Attachment B - Response to the Government Architect's Office Response

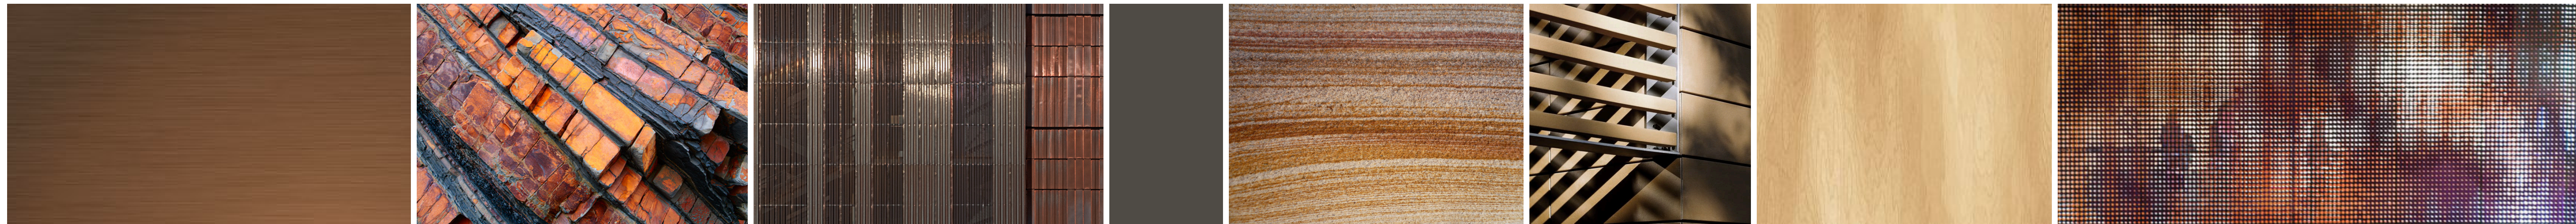
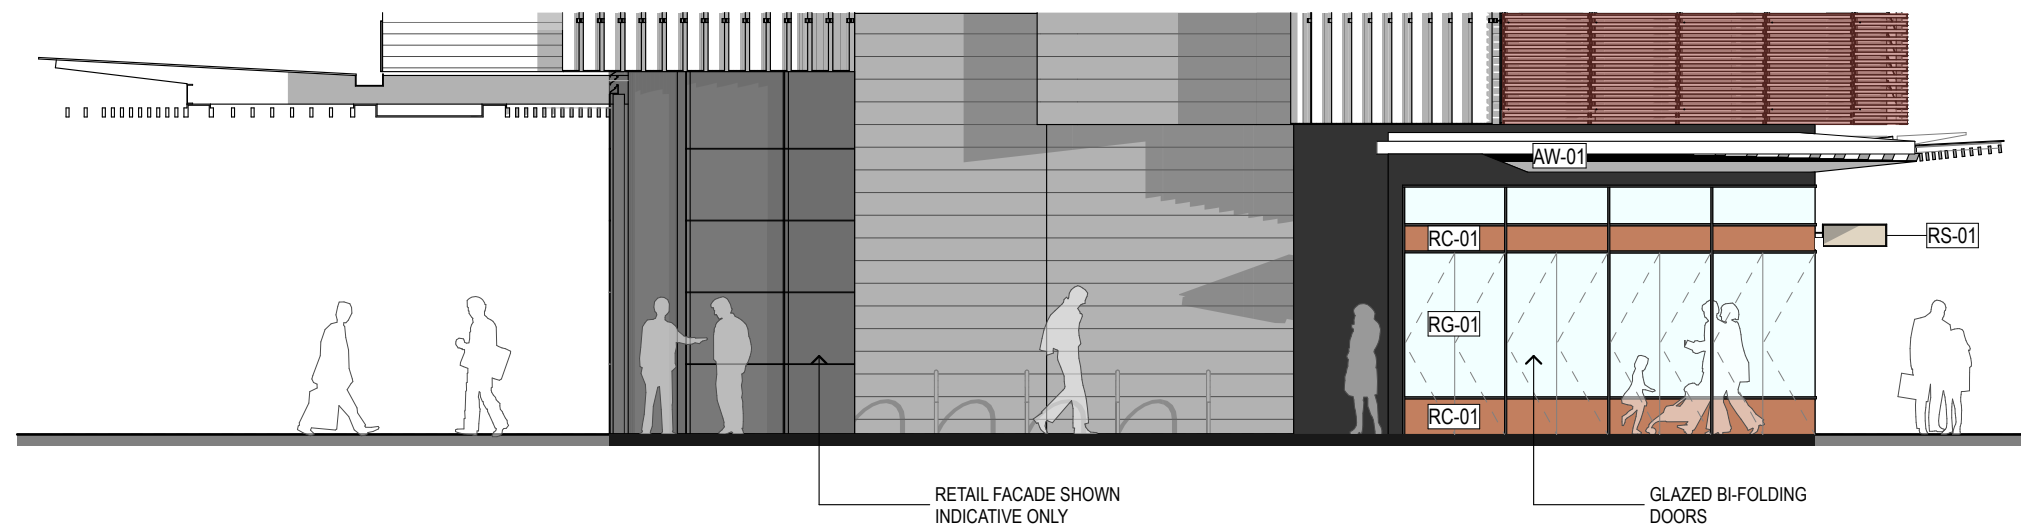
| Government Architect's Office Comment | Applicant Response |
|--|--|
| <p>The proposed non-continuous awnings to Building R8 on Lime Street are not supported. Permanent, continuous footpath protection that is consistent in height and width should be provided along Lime Street in order to promote a high amenity pedestrian environment (including weather protection, drainage and noise transference).</p> | <p>A continuous awning is proposed along building R8 for its length fronting Lime Street as shown below. It is noted that north of where the awning terminates the 'cloud' overhangs the publicly accessible footpath below, providing weather protection in this area. The proposed Modification will therefore provide continuous footpath protection and promote a high amenity pedestrian environment that is not currently provided by the approved Project.</p>  |

| Government Architect's Office Comment | Applicant Response |
|---|---|
| <p>The overall design intent for the shop fronts to Lime Street, including the method for the selection of shopfront types is not clear. Six options are provided for R8. A minimum or maximum number of shop front types would clarify the design intent on this elevation.</p> | <p>See response above.</p> |

Project	BARANGAROO SOUTH
Title	RETAIL Retail Shopfront Options
Drawn By	CHS
Date	15/04/14
Purpose	SP70W
Approved By	JP
Date	
Scale	SCALE 1:100 @ B1 1:250 @ A3
Site No.	BR8
Drawing No.	BR8AD2000051-00
Revision

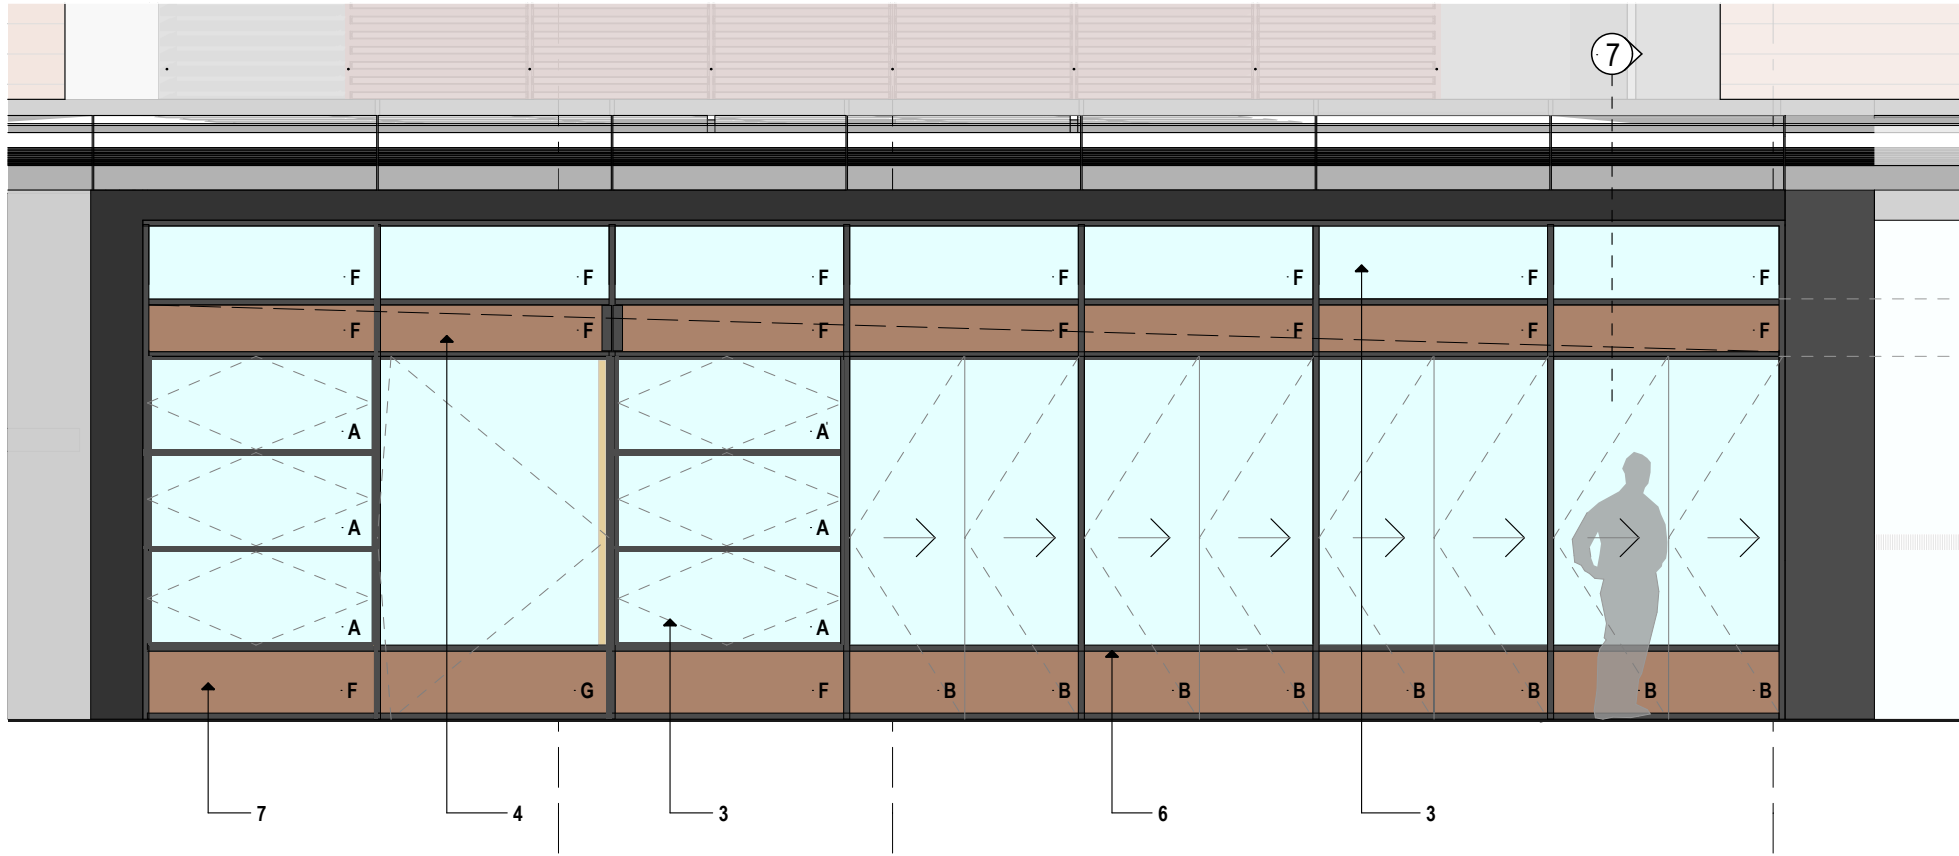
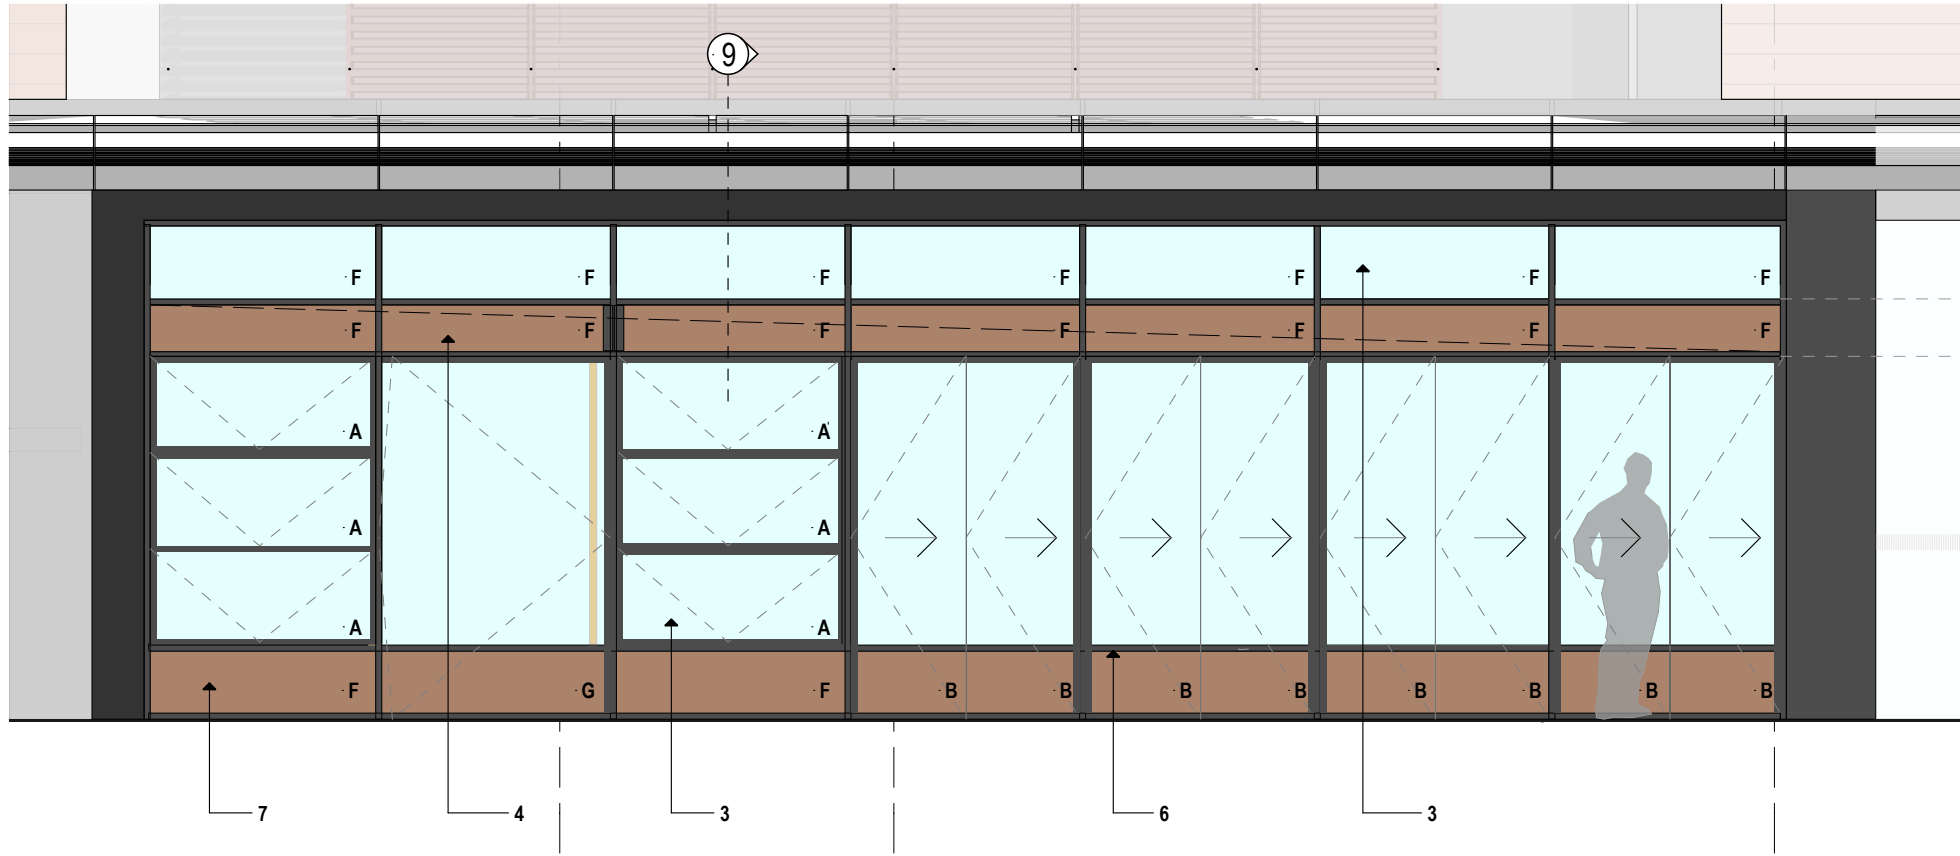
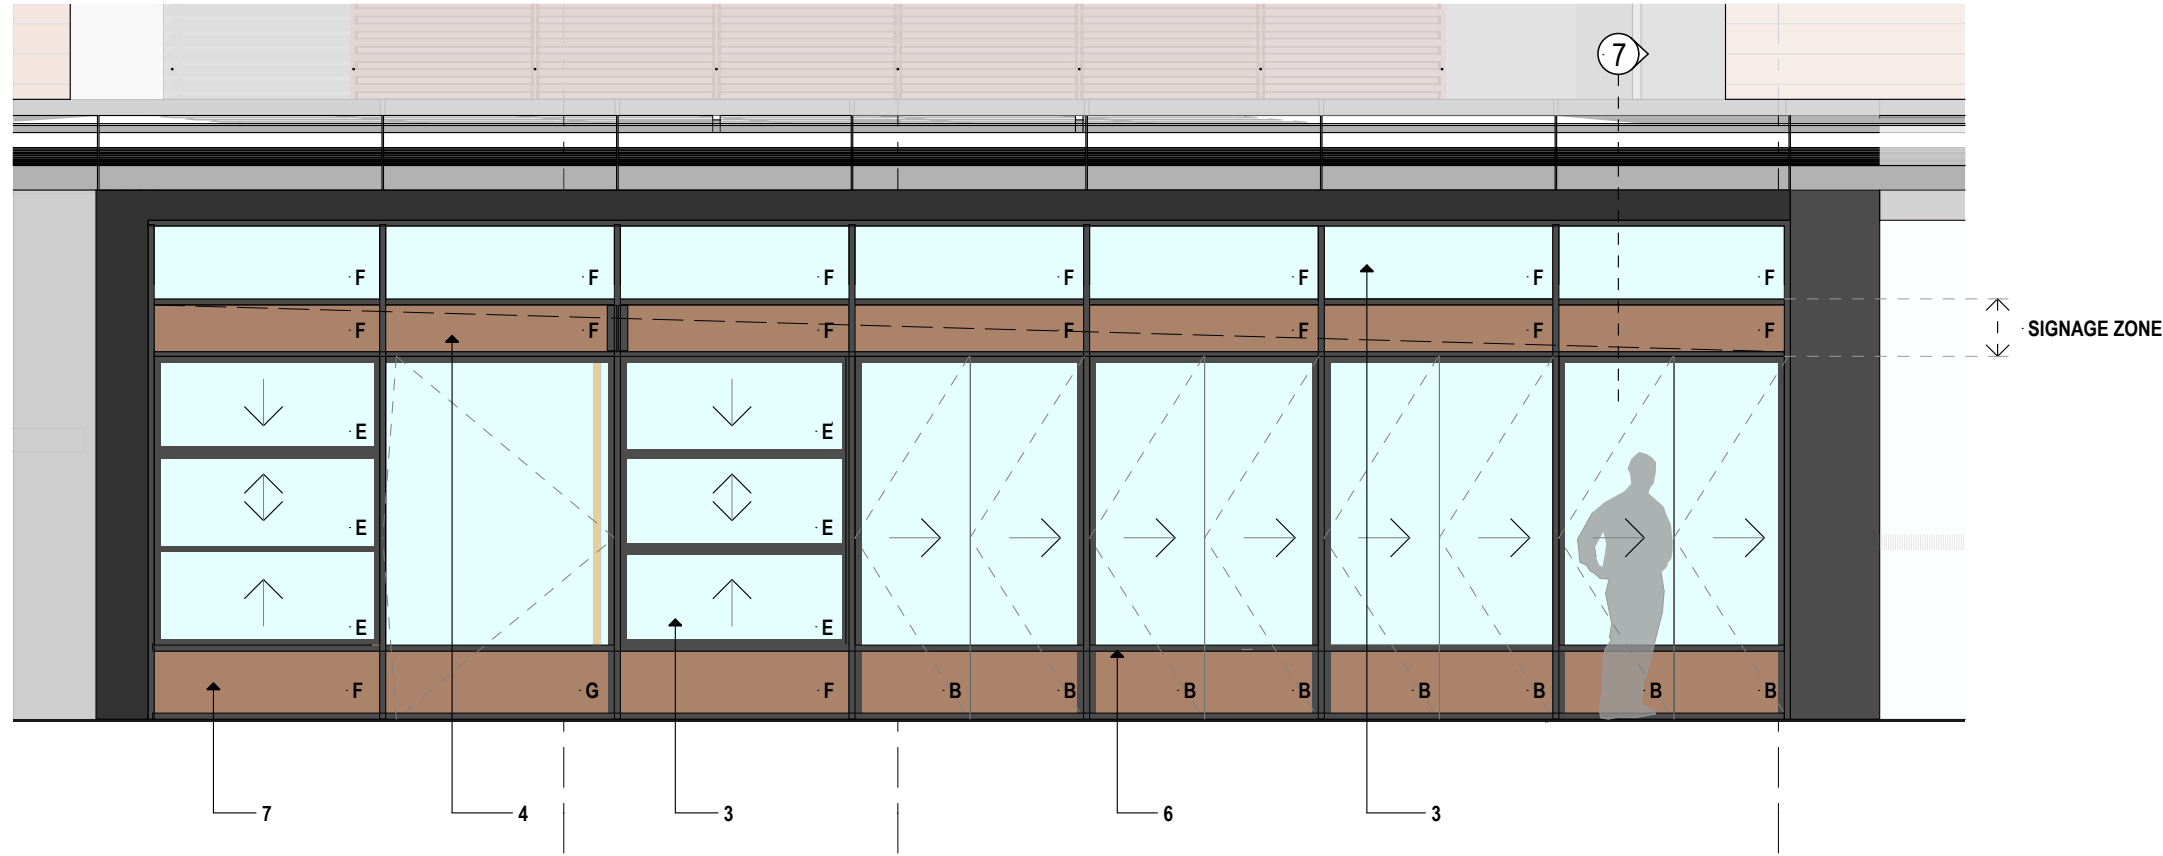
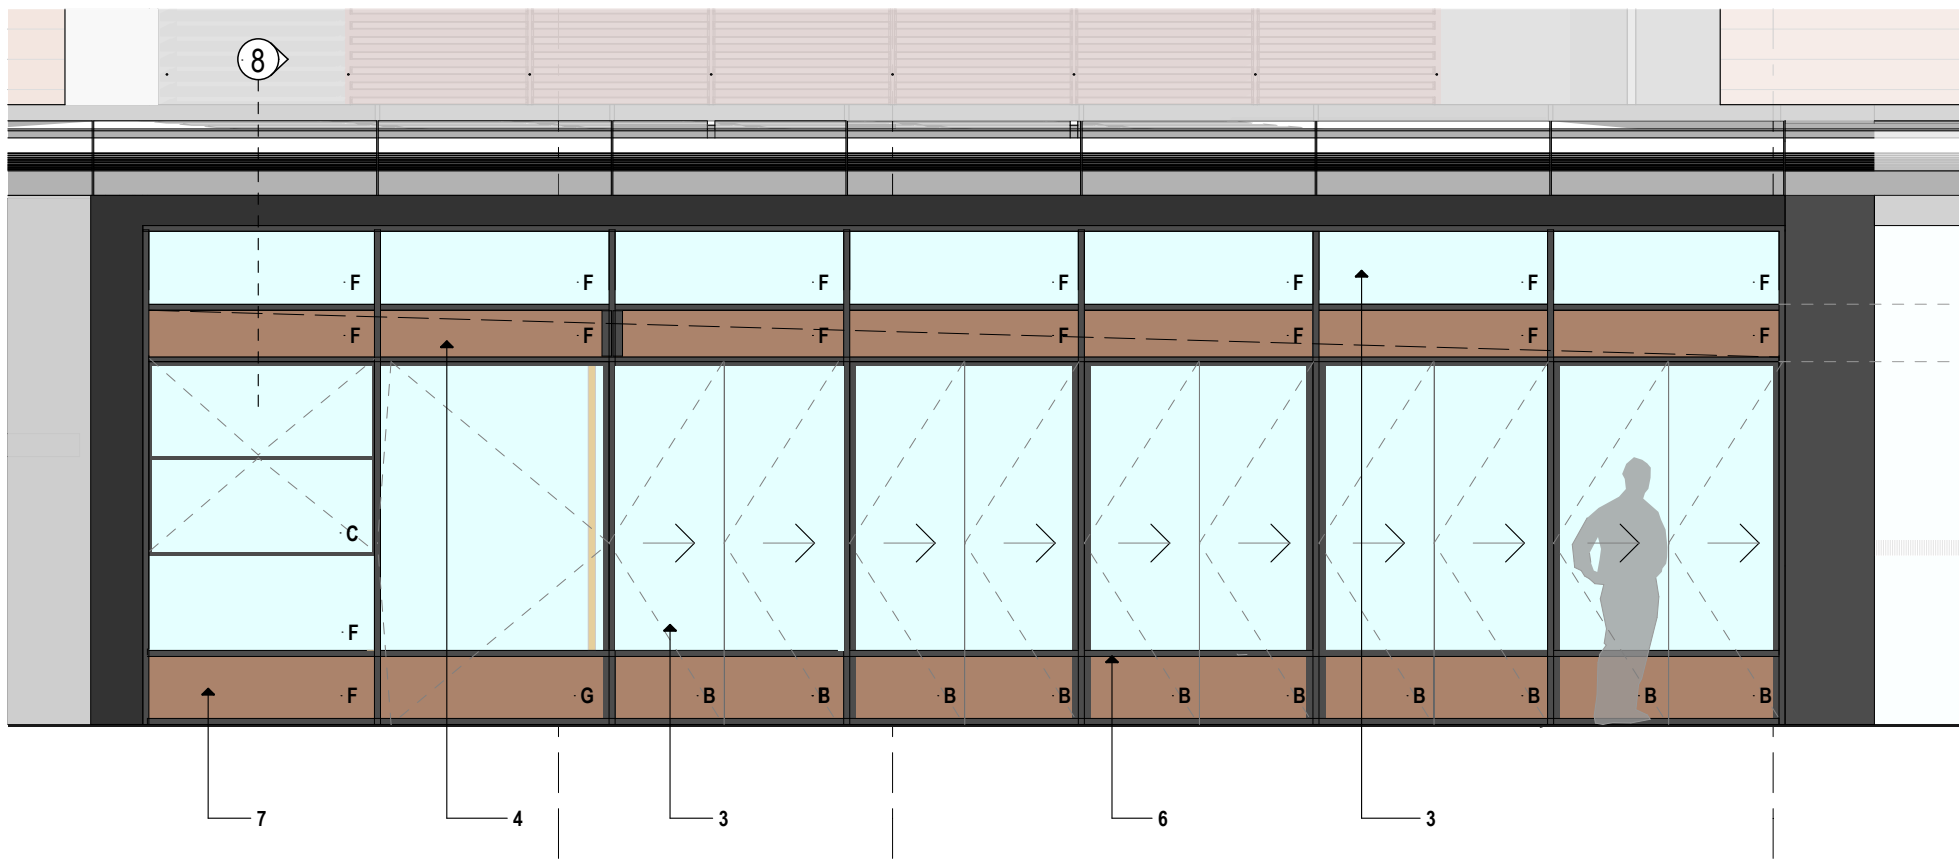
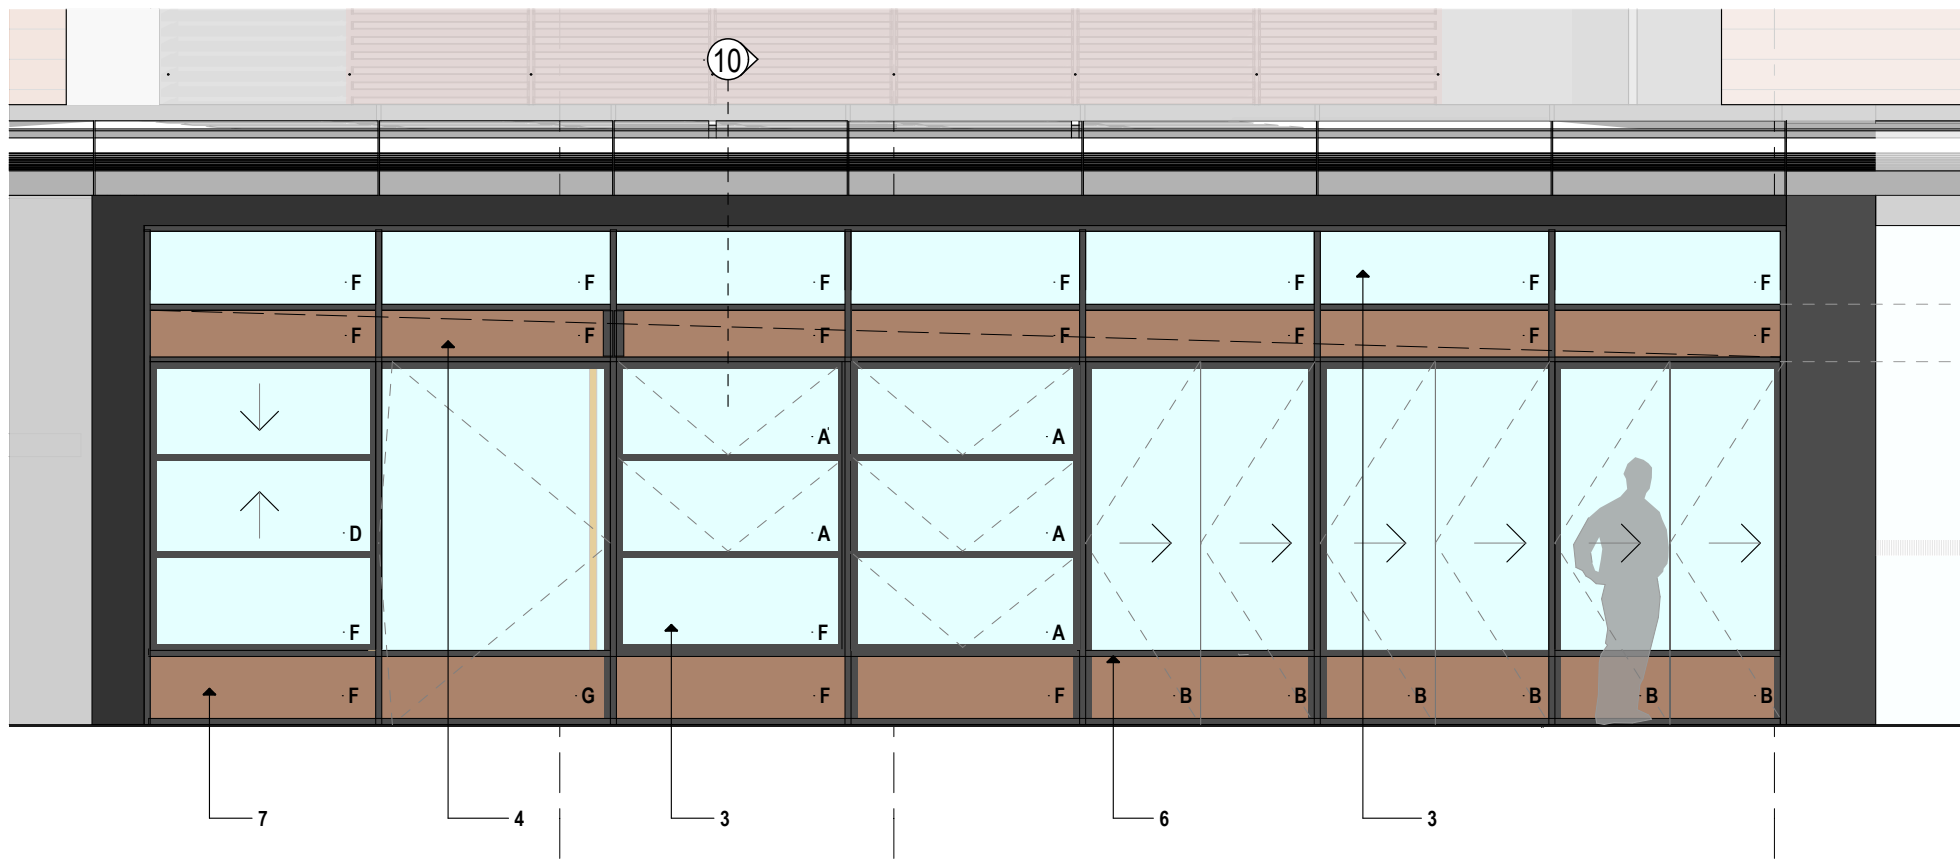
| Government Architect's Office Comment | Applicant Response |
|---|---|
| <p>A drainage solution is not shown from the box gutter of the non-continuous fixed awning.</p> | <p>This detail forms part of the detailed awning designs which have since been submitted and approved separately by the then Director-General.</p> |

| Government Architect's Office Comment | Applicant Response |
|--|--|
| <p>The method of selection of shop front design to Lime Street (R8 and R9) has not been provided, however is likely to be supported (refer items requiring clarifications below).</p> | <p>The method for selecting the shop front design will be determined by the future tenant of each respective tenancy. The design will be selected by the tenant according to their design and operational needs. The range of shopfronts presented have been prepared by the respective architects to be compatible with the relevant building.</p> |
